PARKES SHIRE COUNCIL

16 April 2014

PARKES HOSPITAL REDEVELOPMENT, NEWELL HIGHWAY, PARKES (SSD 6107)

diagram showing site access ①

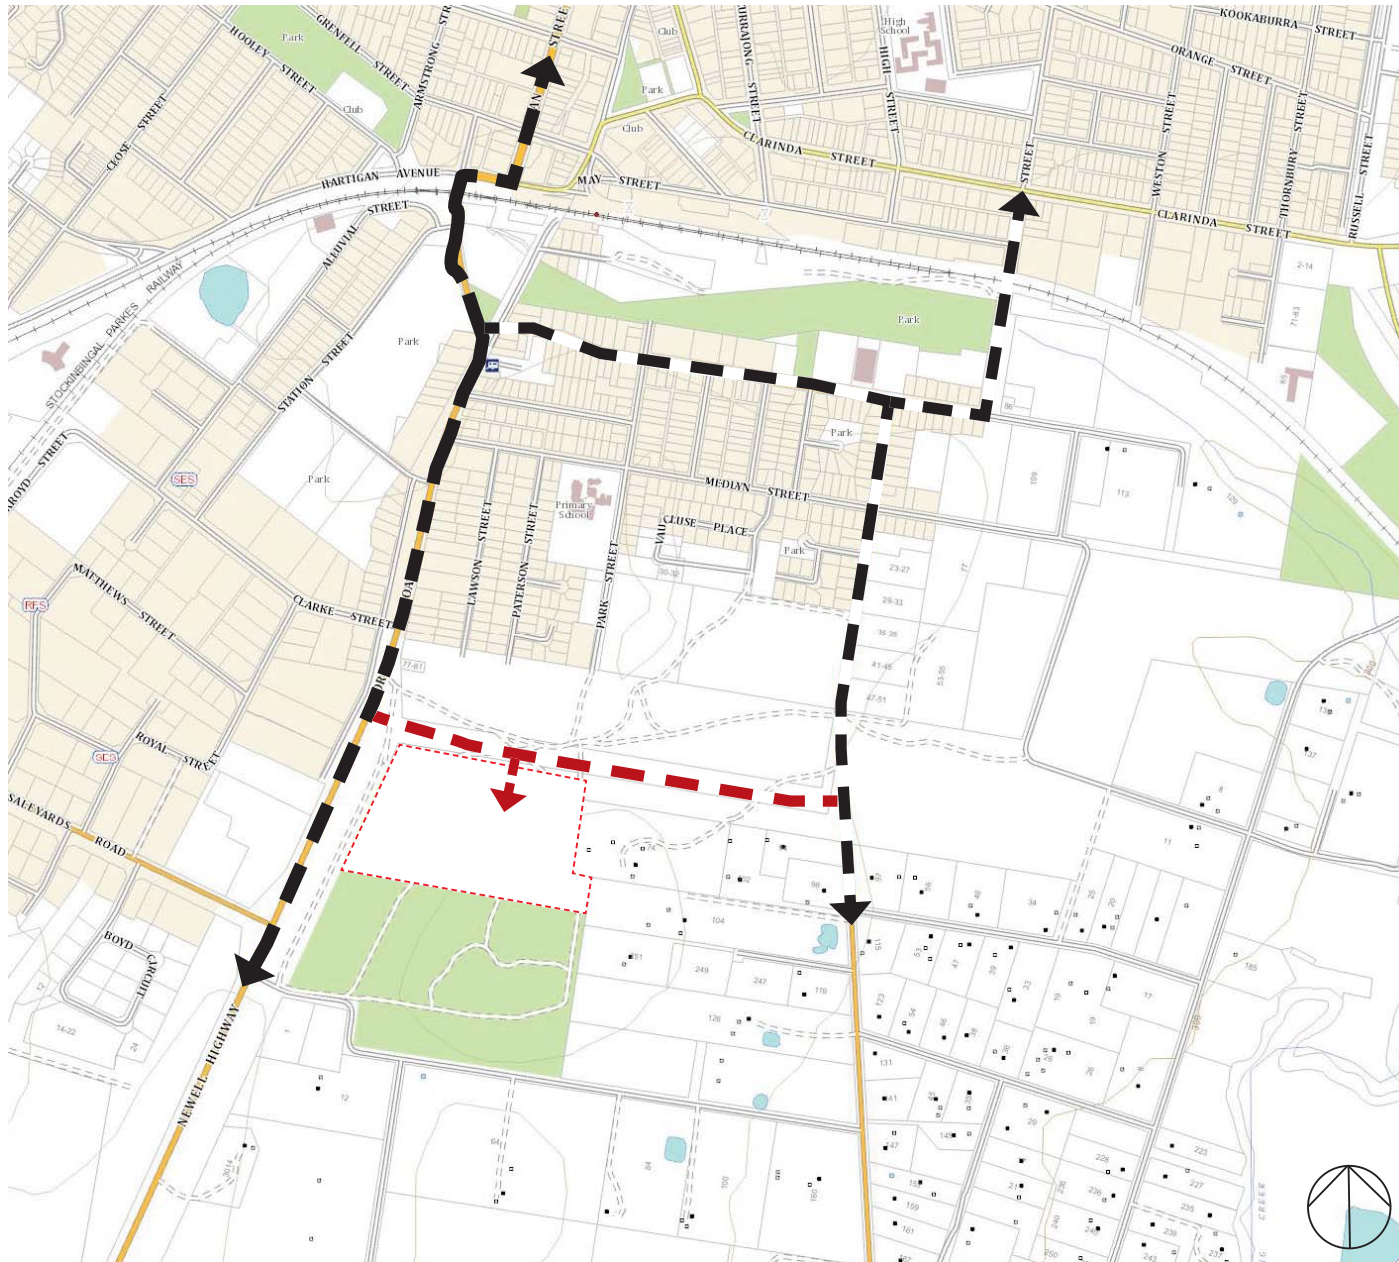
- Section 5.6.7 Walking and Cycling states that there is potential for the existing path along the eastern side of the Newell Highway to be linked to the shared path facilities along the Southern Ring Road. It is recommended that pedestrian access is provided from the existing path along the Newell Highway to the Hospital building.

proposed car parking diagram

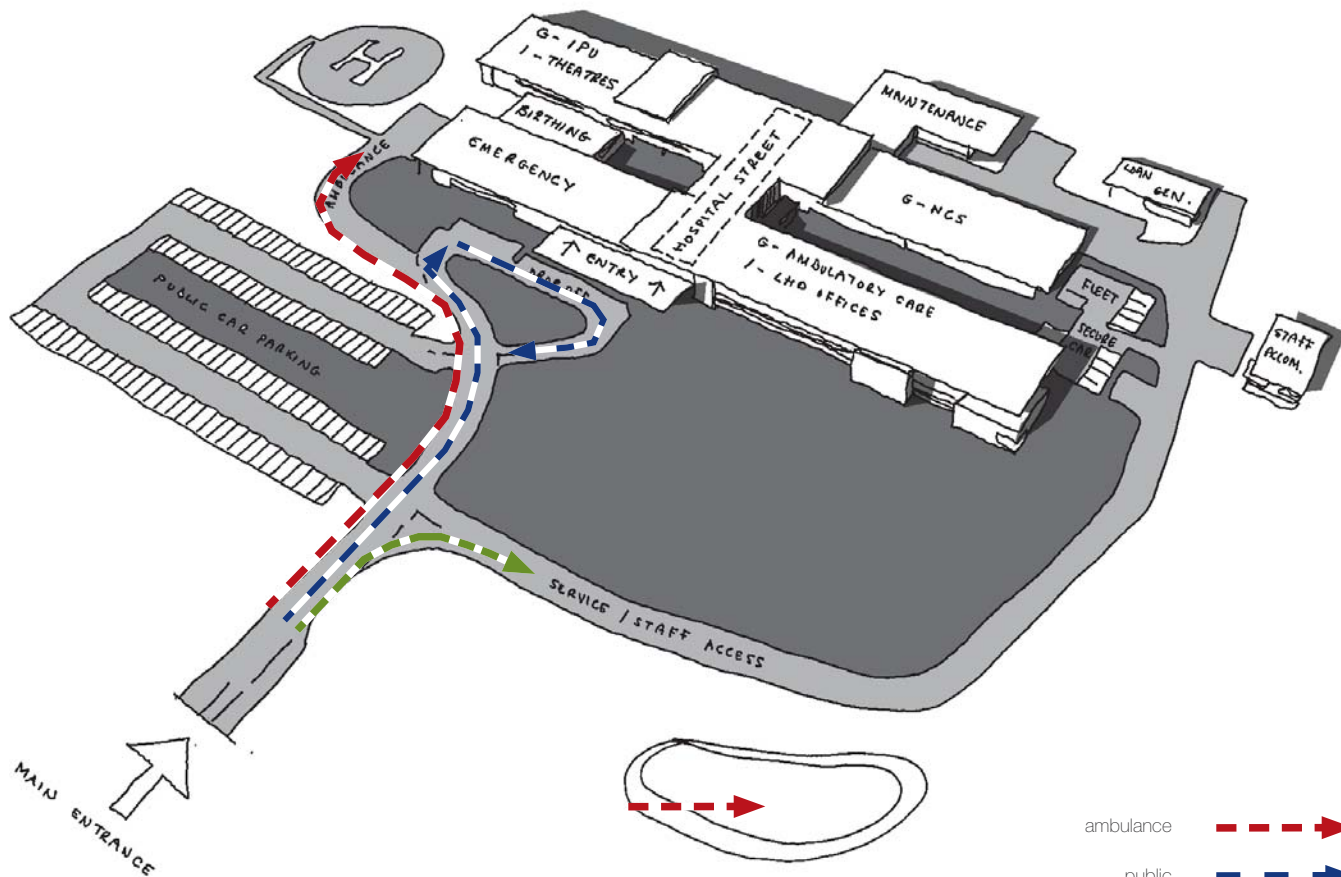
- The proposed parking arrangements appear adequate for current proposal. Additional facilities or further development of the site may require increase to the patient car parking.
